SUBJECT: WDFW COMMENTS ON CU-23-00007 Cle Elum Transfer Station

RE: CU-23-00007 Cle Elum Transfer Station

RE: CU-23-00007 – Cle Elum Transfer Station Re-design  
SR 903 milepost 3.45 Rt.

**JACOBS**  
 CIVIL  
**OVERALL EXISTING SITE PLAN**

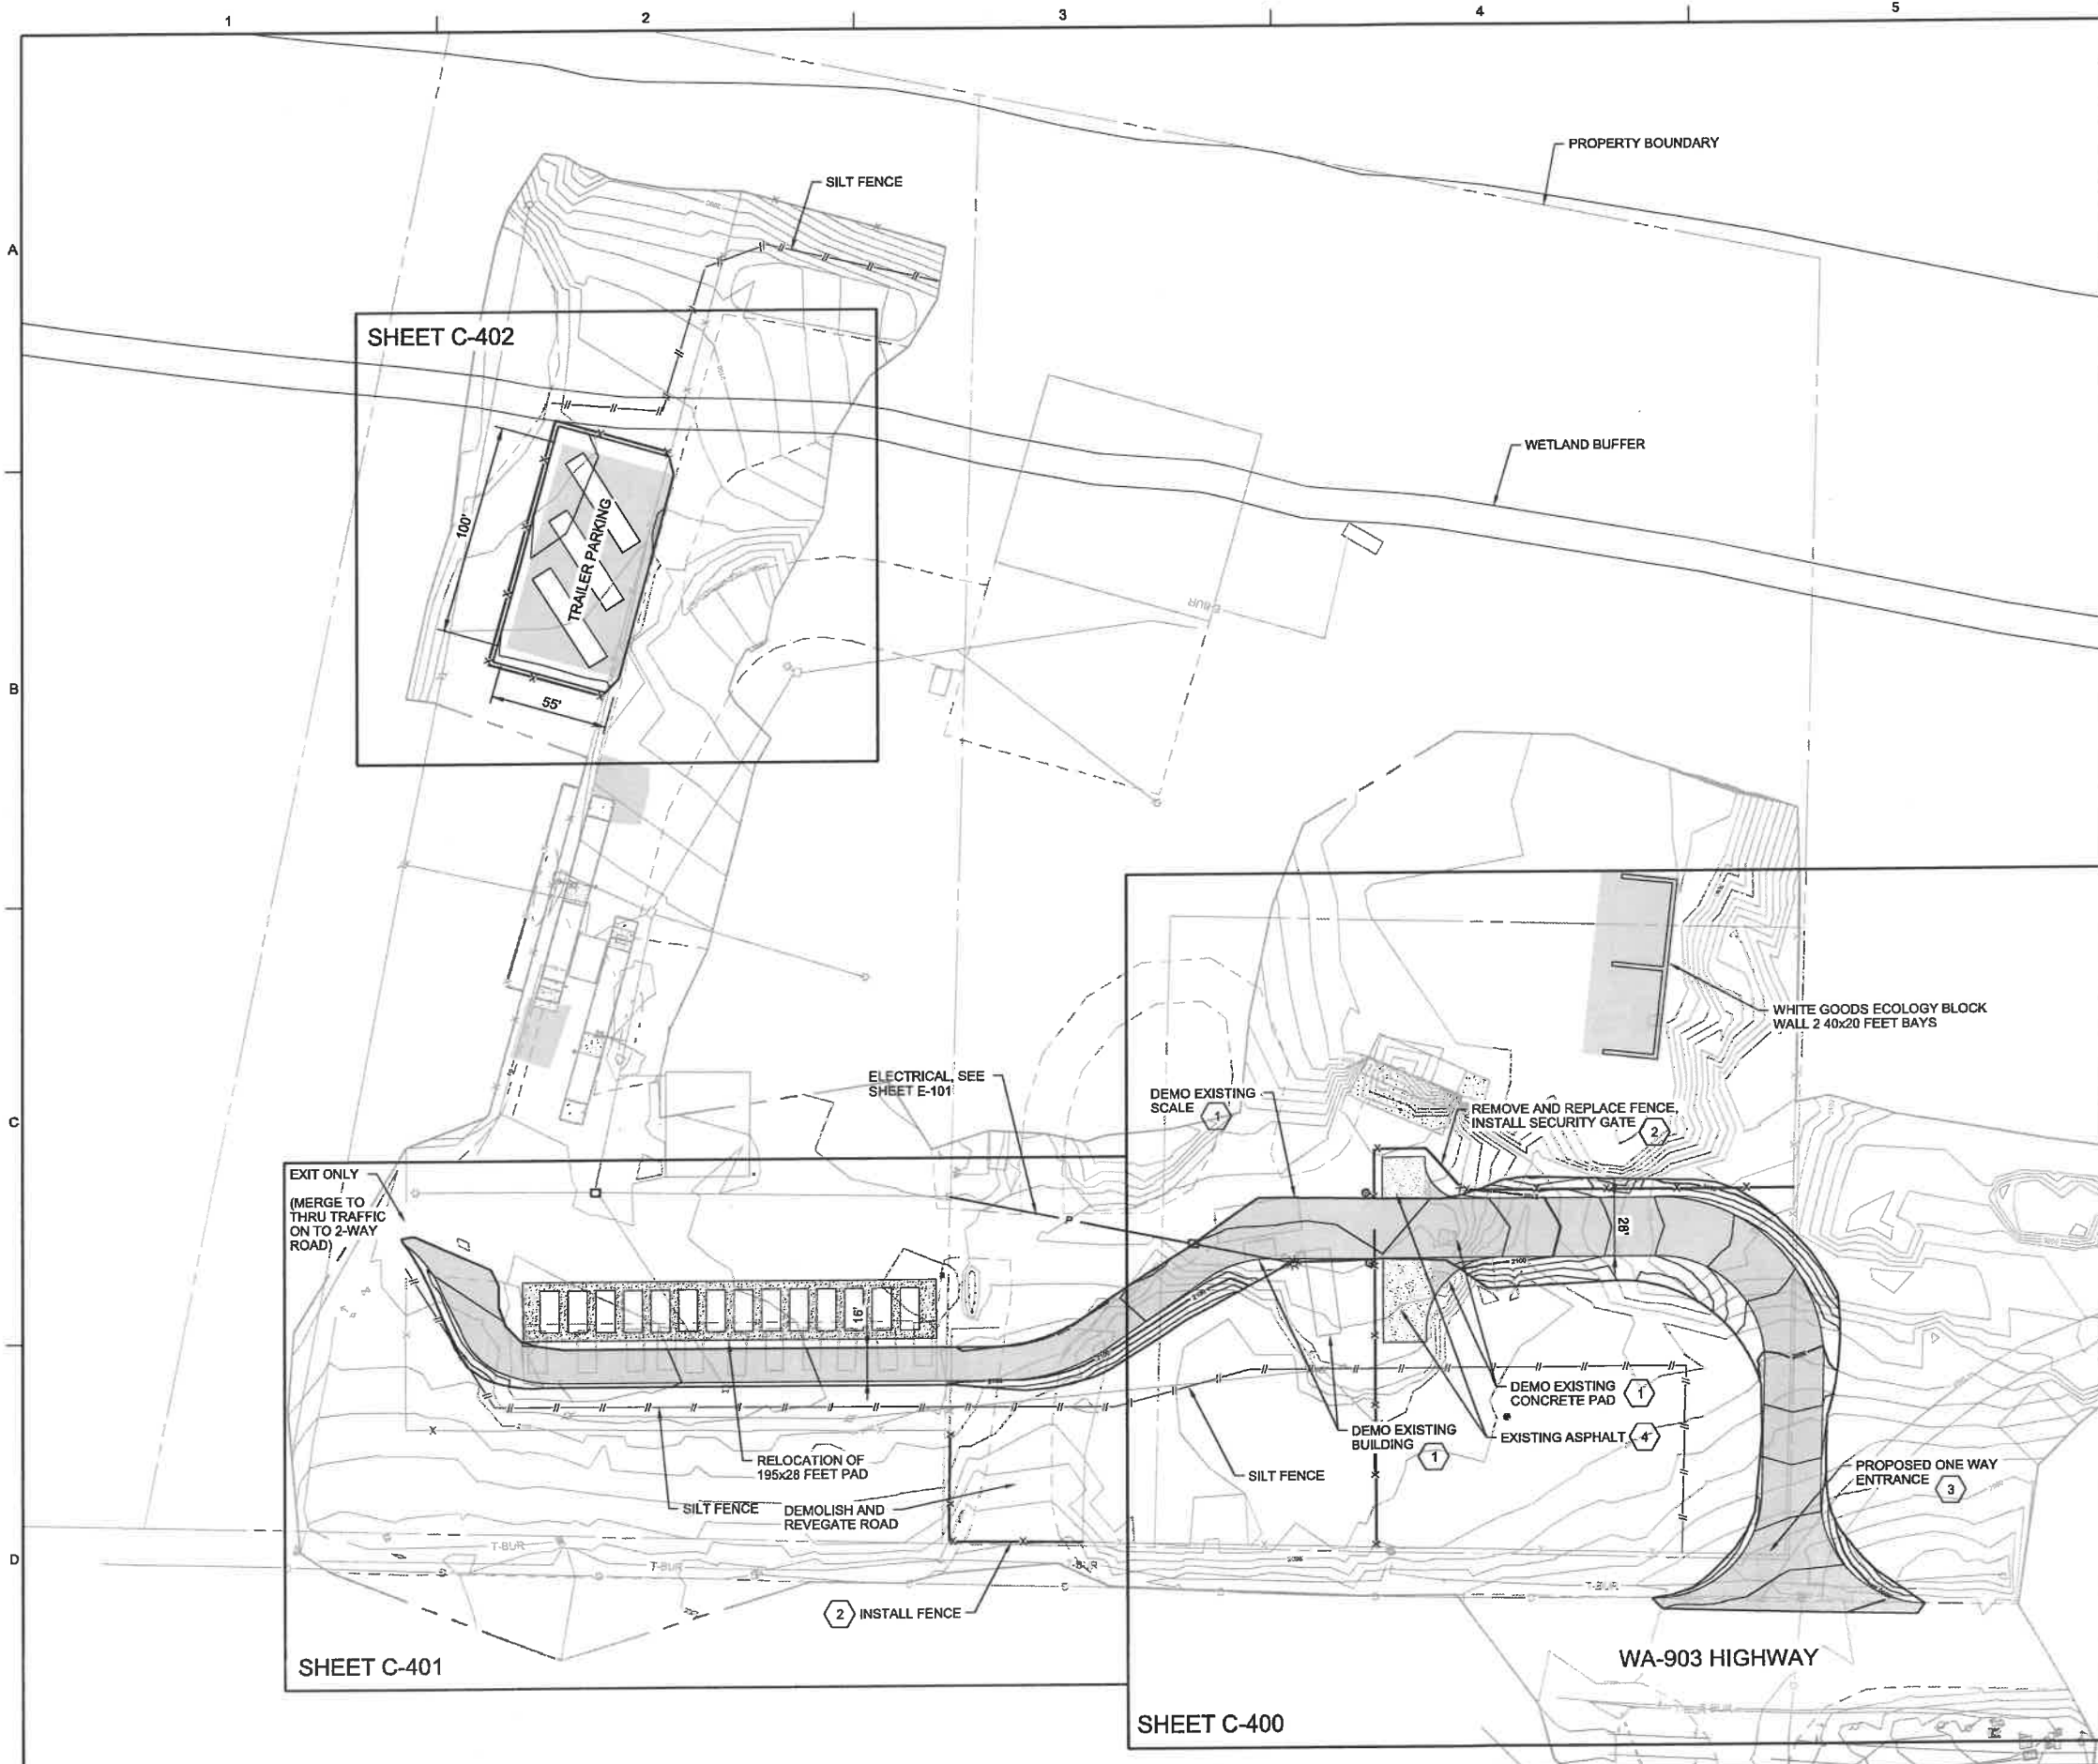
The site plan sheets are unclear, but there appears to be potential overlap between the clearing limits for the building of the trailer parking and the riparian area of Crystal Creek. WDFW requests the opportunity to meet with the applicant, preferably on site, to clarify clearing limits in respect to the riparian zone of Crystal Creek. If the proposed clearing limits do overlap with the riparian setbacks for a Type F stream, WDFW requests that either the clearing limits be modified to have no impact or for the applicant to prepare a mitigation proposal to offset the impacts of the clearing. Further, while not part of the proposed application there are existing impervious surfaces within the riparian area of Crystal Creek. WDFW would recommend to explore if those areas could be revised and potentially rehabilitated to provide riparian habitat. WDFW requests that exploring that possibility also be part of the proposed meeting.

DATE	JUNE 2023
PROJ	KITT002
DWG	C-400
SHEET	5 of 11

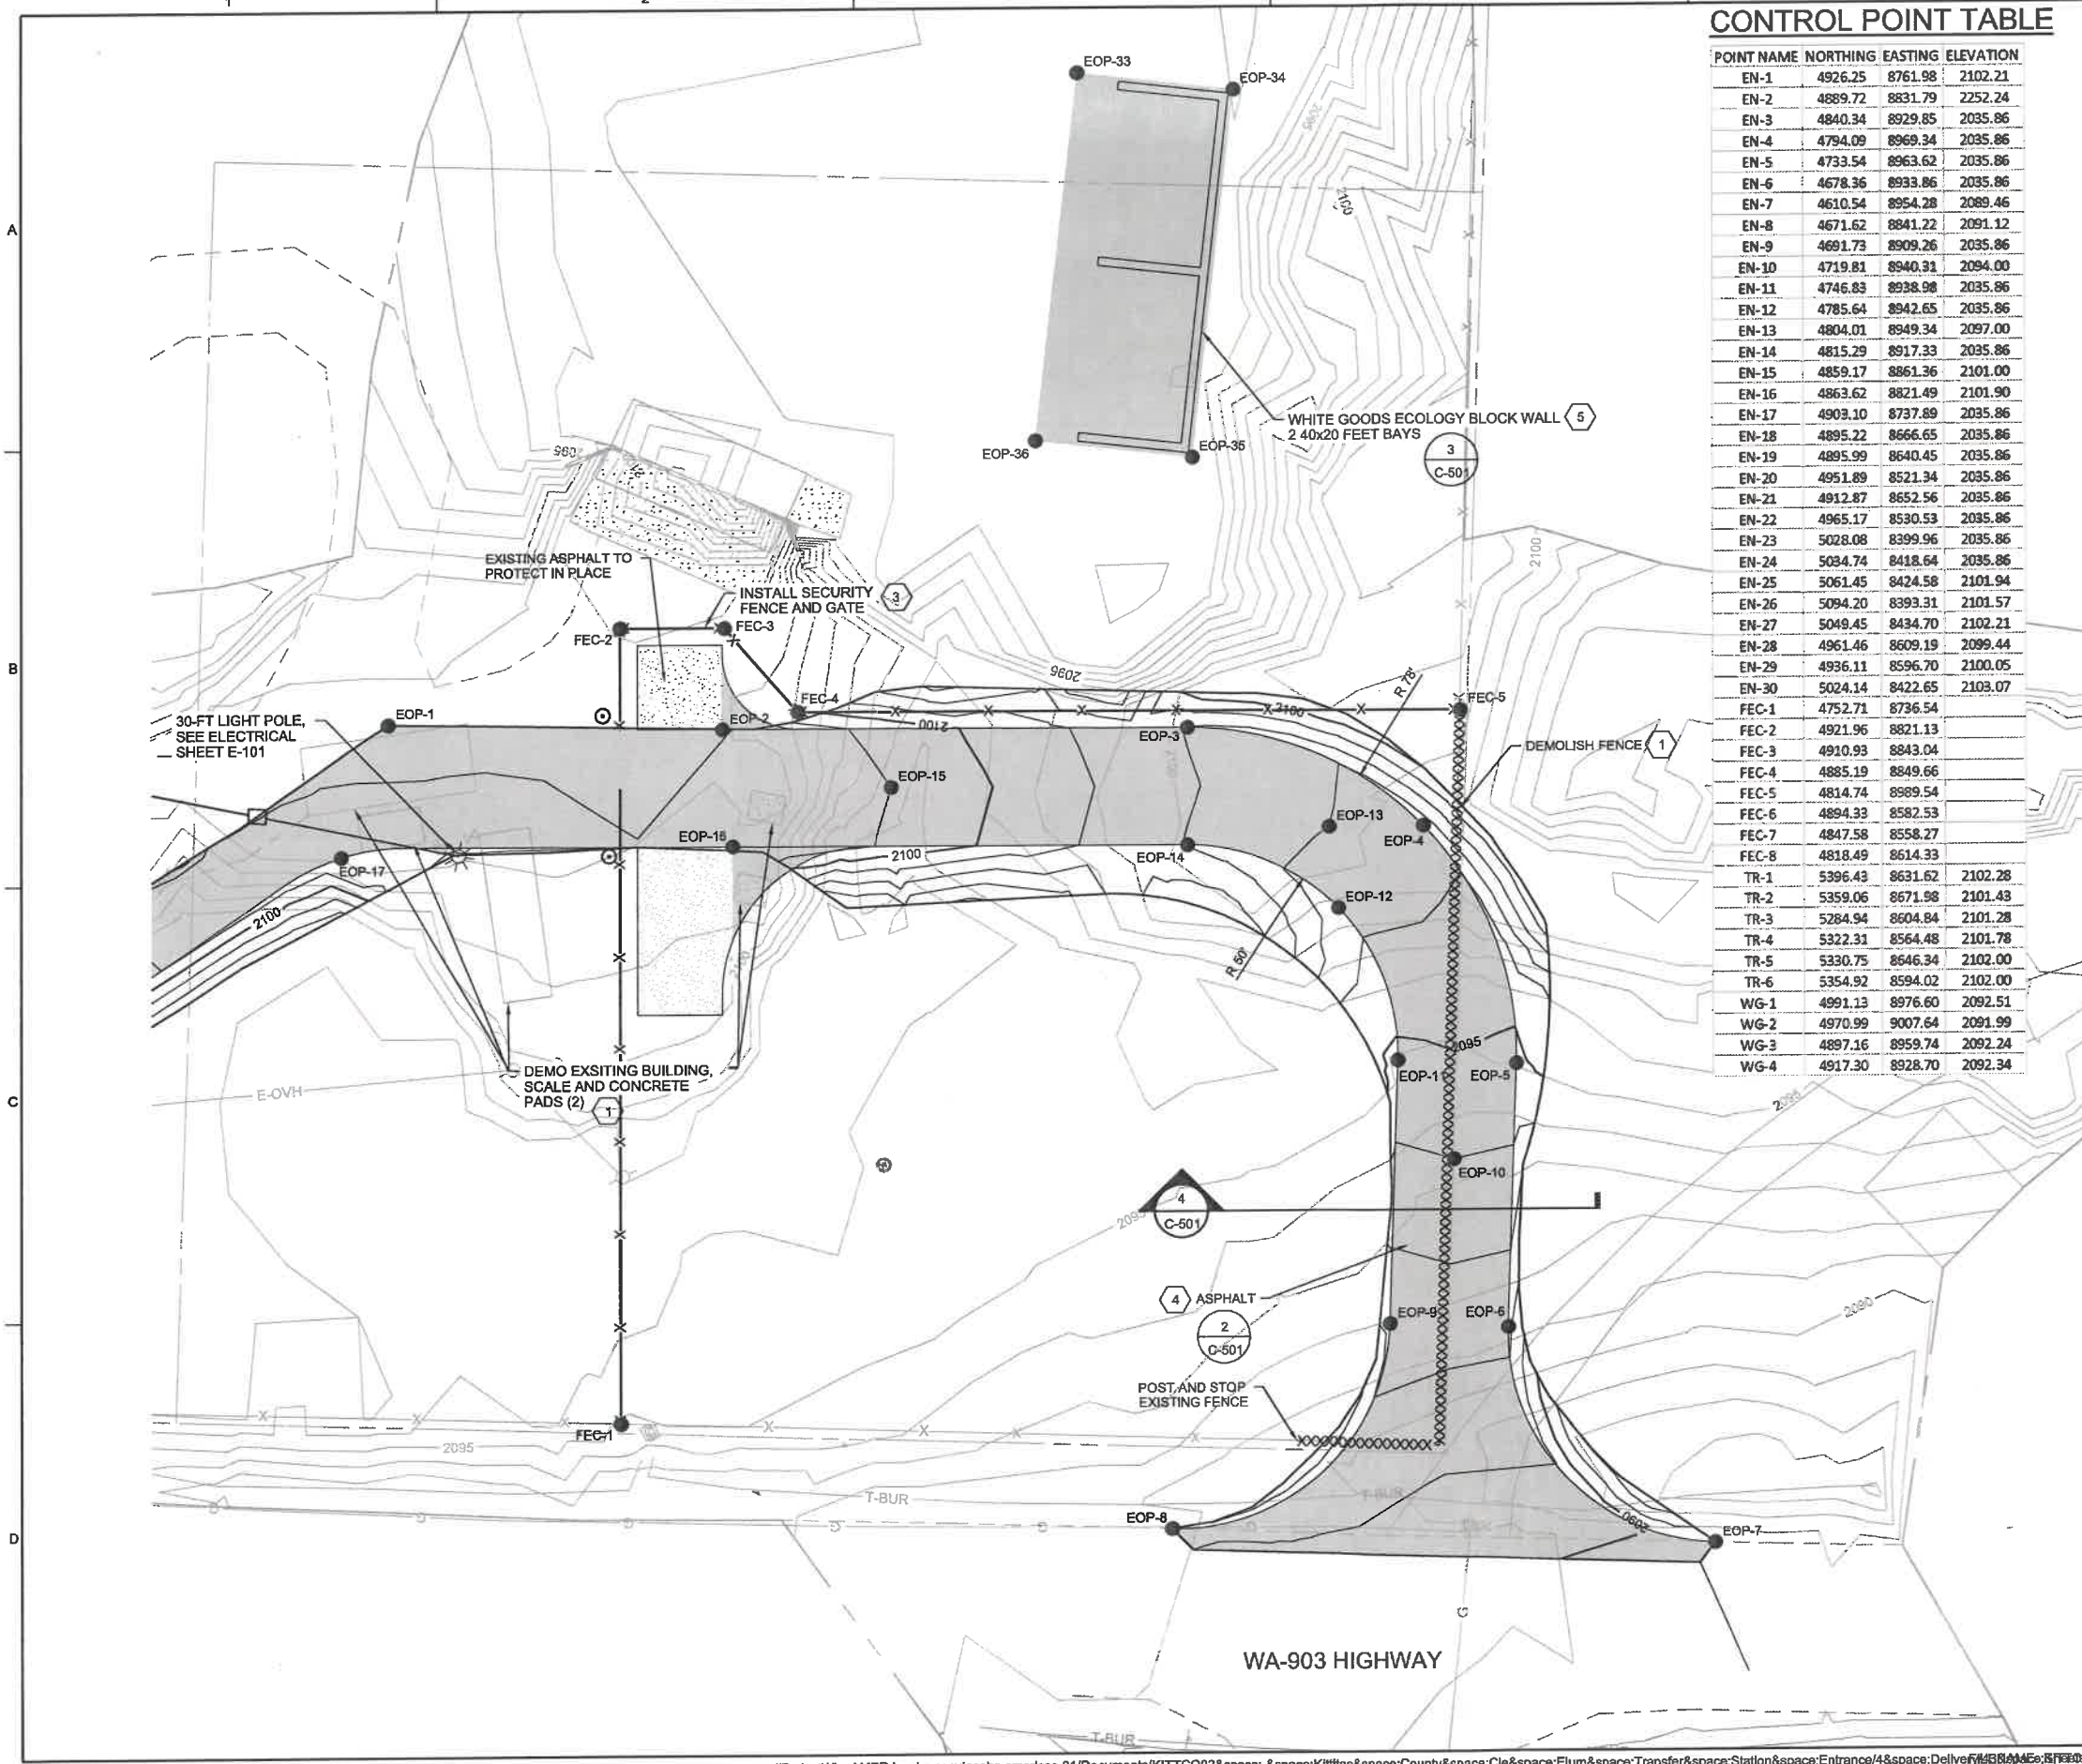
Public Health is commenting on the CU-23-00007 Cle Elum Transfer Station. Please note on the side of the new entrance there is a well that needs to have a protected 100 foot radius. The sanitary control area should be maintained free from potential contamination, including any roads, asphalt, concrete, or cement pads for waste containers or collection bins.
